**KIRKLEES METROPOLITAN COUNCIL
INVESTMENT & REGENERATION SERVICE**

Reference No:	2023/62/91068/E
Site Address:	57, Douglas Avenue, Soothill, Batley, WF17 6HG
Description:	Erection of part single storey/part three storey rear extension, front and rear dormer extensions and external alterations following removal of existing conservatory
Recommending Officer:	Nicole Helliwell

Officer Report

REAR ELEVATION

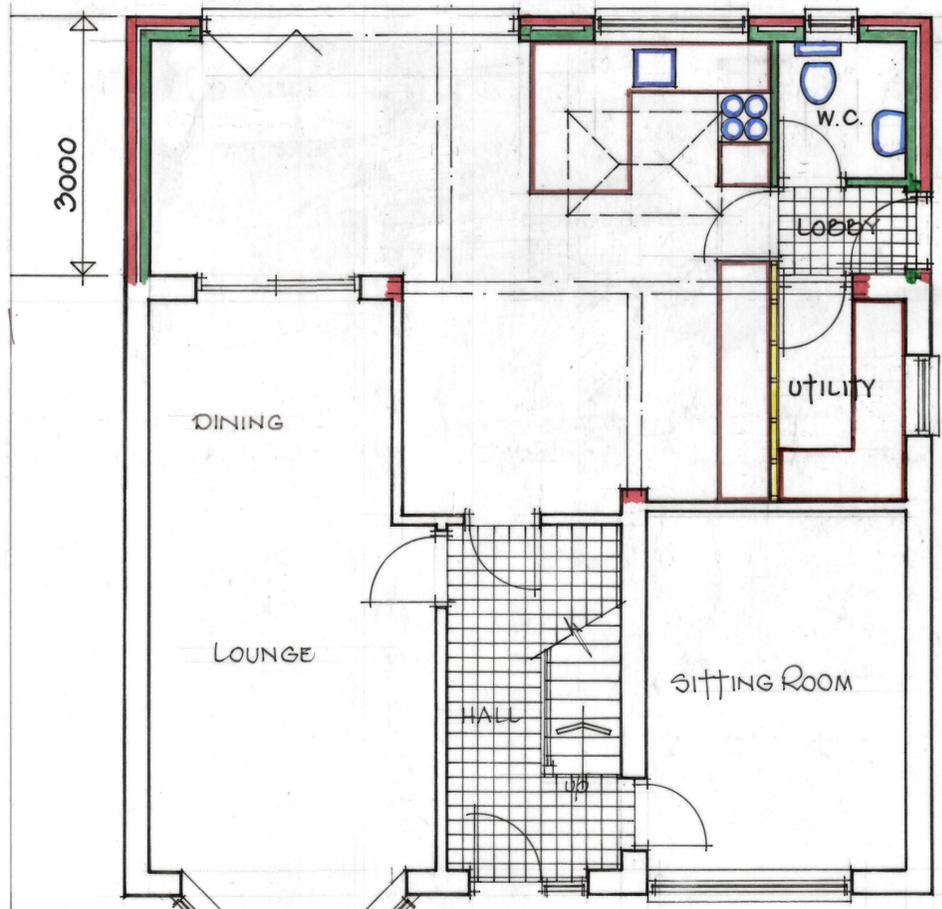
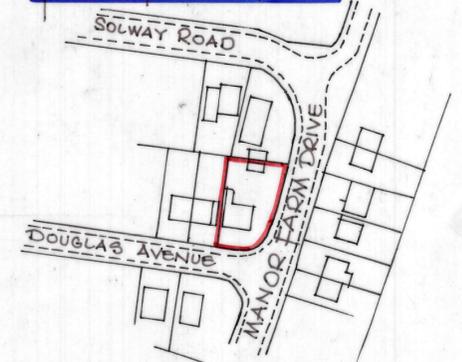
The traditional vertical dormer windows would be located within the north and south facing roof planes. The dormers would be set back from the eaves and sited below the existing ridge line. Although the application form states that the dormers would be faced in dark grey UPVC cladding or tile hanging, should the application be approved, a condition will be added requiring the facing materials to be of a similar colour to the existing roof tiles. The dormer windows would also be of an appropriate size and design and would generally align with the existing fenestration. Although there are examples of dormers on bungalows within the immediate street scene, it is noted that this row of two storey dwellings are devoid of dormer extensions. Furthermore, the application property occupies a prominent corner plot where the proposed dormers would be highly visible. On this basis, it is

considered that the proposals would unduly harm the character and appearance of the host property and surrounding area and cannot be supported in terms of visual amenity.

The proposed enlargement would extend approximately 3m from the existing rear elevation and would be faced in brick to match the appearance of the original dwellinghouse. The single storey element would incorporate a flat roof form and the three storey element would feature a dual pitched design finished in concrete tiles. It is noted that extension would lack subservience and would alter the scale and form of the original build. Furthermore, due to the property's location on a prominent corner plot, the enlargement would appear incongruous and would be highly visible from public vantage points. On this basis, the enlargement would significantly impact upon the character and appearance of the host property and wider street scene and cannot be supported from a visual amenity perspective.

15 Manor Farm Drive is a detached bungalow located to the rear of the application site. The plans confirm that the proposed part single storey/part three storey rear extension would occupy a position approximately 14.7m from the neighbouring property. Furthermore, it is noted that the rear dormer extension would be positioned approx. 18m from the neighbour's side elevation. It is considered that this is not sufficient separation distance between habitable rooms and the proposal would therefore give rise to an unacceptable overlooking relationship. As such, the harm caused to this neighbour would be significant and cannot be supported in terms of residential amenity.

The proposed part single storey/part three storey rear extension and rear dormer extension would create an unacceptable overlooking relationship to the occupiers of no.15 Manor Farm Drive. On this basis, the proposed would fail to accord with Policy LP24 of the Kirklees Local Plan, Key Design Principle 5 & 6 of the House Extensions and Alterations SPD and Chapter 12 of the National Planning Policy Framework.
